**Drayton Coal Mine
Section 75W Modification
MP 06_0202 Mod 3**

NSW Trade & Investment, Regional Infrastructure & Services, Division of Resources & Energy (DRE) has reviewed the *Drayton Mine Project Approval Modification 3 Environmental Assessment* (EA) dated April 2012. DRE provides the following comments:

**RE: REVIEW OF THE EA FOR THE PROPOSED MODIFICATION TO THE DRAYTON COAL MINE AND
RECOMMENDED CONDITIONS FOR APPROVAL**

DRAYTON MINE - PROPOSAL TO EXTEND MINE FOOTPRINT (DA 06-0202 MOD 3)

Figure 4.3 Minesite Water Management Schematic

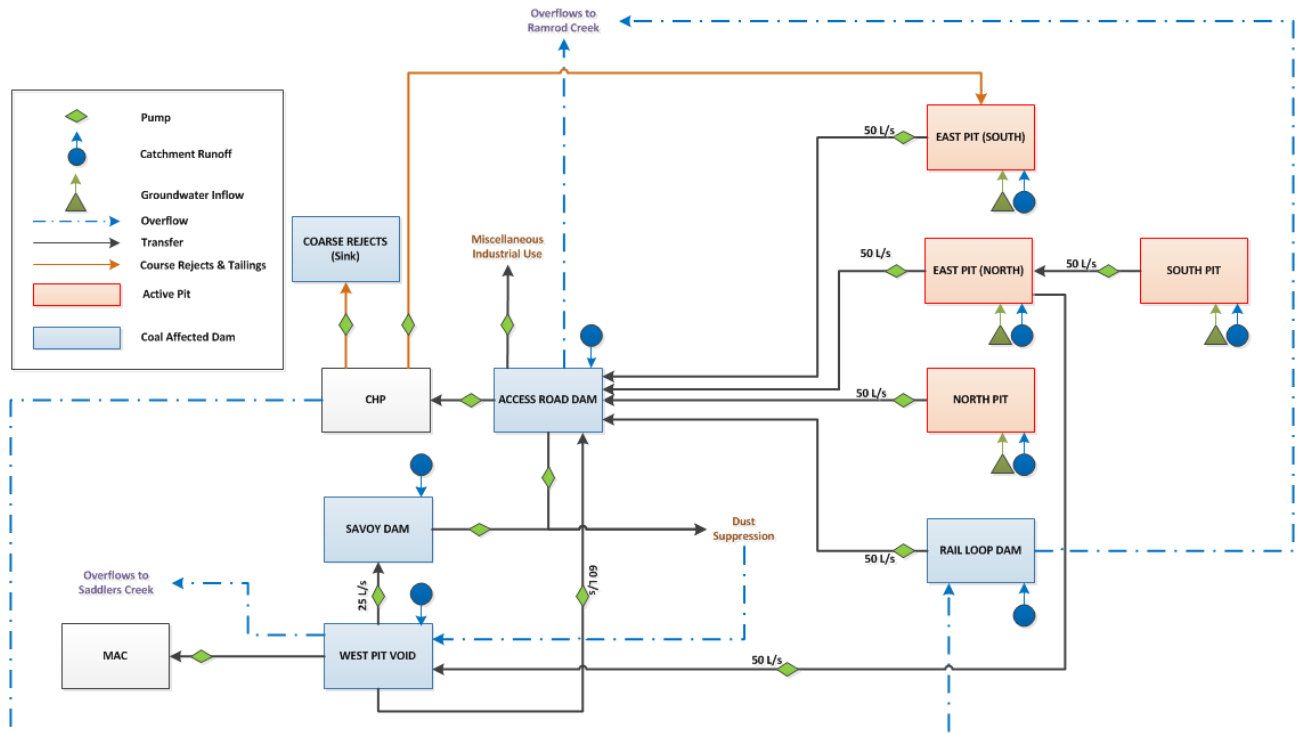
The mine site water management schematic diagram shown in Figure 4.3 of Appendix D indicates that the Access Road Dam and the Rail Loop Dam have the potential to over flow to Ramrod Creek. Both these dams are used to store saline mine water. The Drayton Coal mine operates within the area of the Hunter River Salinity Trading Scheme, which operates to manage the discharge of saline water from industry.

While Section 2.5 of the Surface Water Impact Statement states that the Drayton Mine operates as a closed system to ensure that all mine water stored on site is utilised on site, it appears that the current mine water management system does allow for the offsite discharge of saline mine water.

Section 120 of the *Protection of the Environment Operations Act 1997* prohibits water pollution. Condition L1.1 of the Drayton Mine Environment Protection Licence (EPL 1323) reinforces the need to comply with this requirement. The effect of this condition is that saline mine water cannot be discharged from the site. It is recommended that Anglo Coal (Drayton Management) Pty Ltd ensure that the water management plan is designed to comply with these requirements.

The EPA notes that the proponent intends to increase the size of the Rail Loop Dam by 50ML from 18ML to 68ML in order to prevent uncontrolled spills. The EPA recommends that if consent is granted, that the conditions of consent include a requirement for works to increase the capacity of the Rail Loop Dam are completed within 3 months of modified consent being granted.
